CITY OF ALBUQUERQUE

December 14, 2015

RE: **Weck's Restaurant – 730 Juan Tabo NE**
Drainage and Grading Plan
Engineer's Stamp Date 11-2-2015 (File: K22D006A)

Project Title	WECK'S RESTAURANT 730 Juan Tabo Blvd NE Albuquerque, NM 87123
Sheet Title	GRADING PLAN

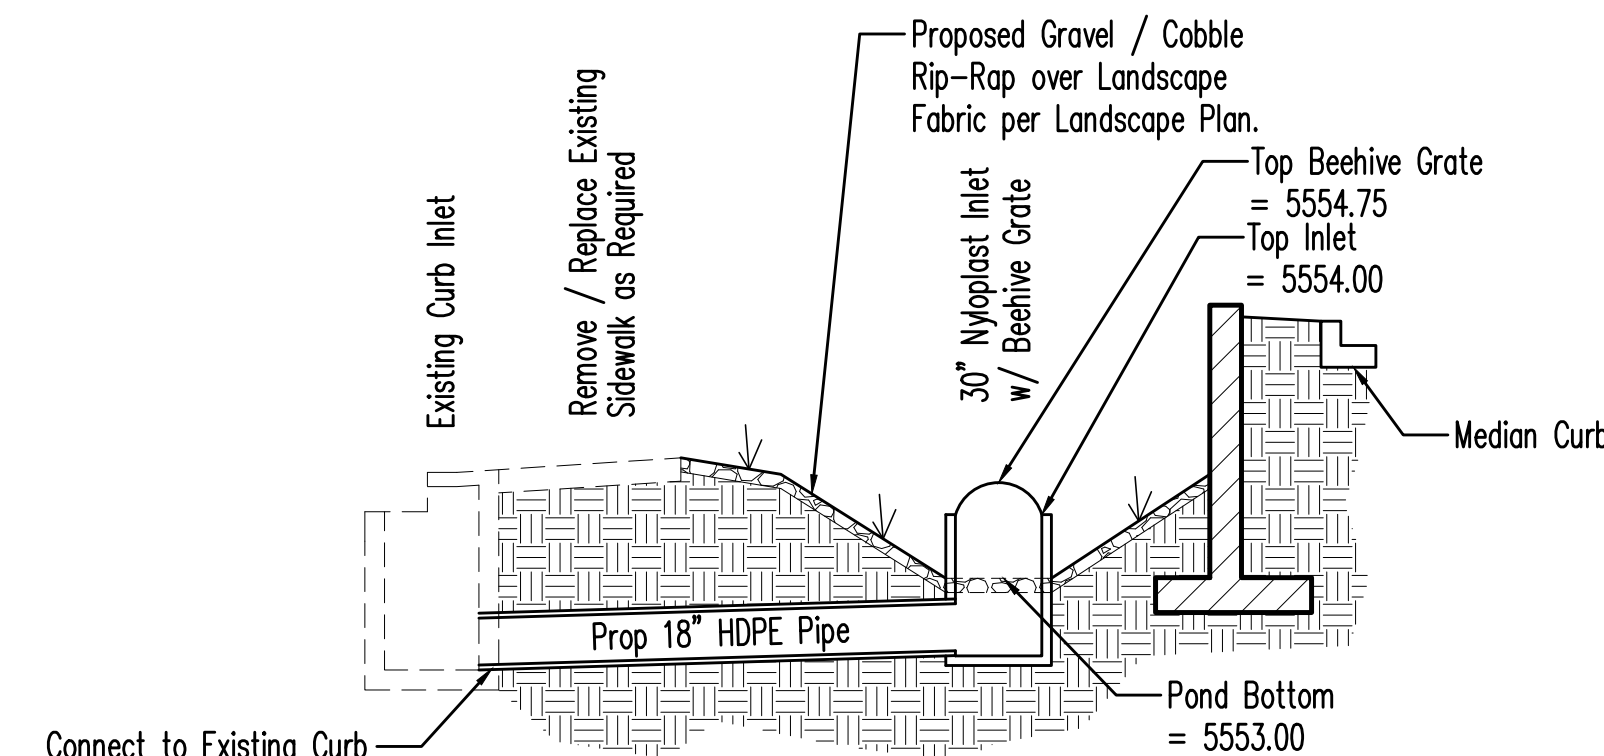
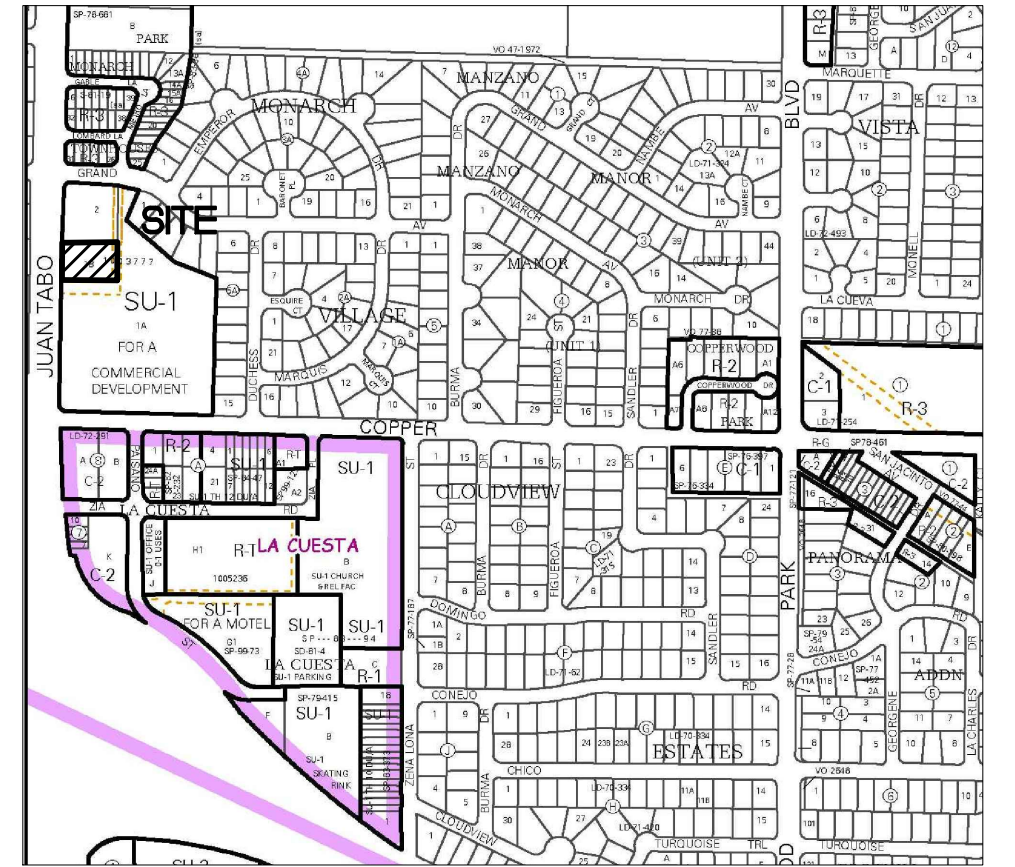
1. The outlet of the pond relies on 1-foot of head to discharge the 100-year, 13 cubic feet per second peak flow. The top of the proposed beehive grate is set at elevation 54.75. It is assumed that the "bottom" of the grate is set at 54.00 to ensure a head of 1-foot from the top of the pond which is set at 55.00. Otherwise, the height of the inlet needs to be adjusted.

2. The pond is proposed within a 7-foot public utility easement. Are there utilities that will need to be lowered/relocated? If so, they will need to be fully coordinated prior to construction; a Certificate of Occupancy will not be issued if the pond volume is reduced during construction.

3. There is a 9.67% grade label shown that appears to be a typo along the southern sidewalk next to the building.
4. The calculation of the water harvesting pond volume appears to be overestimated. If the inlet opening is set at elevation 54, the volume "provided" in the pond between contours 54 and 55 (969 cubic feet) is not harvested.
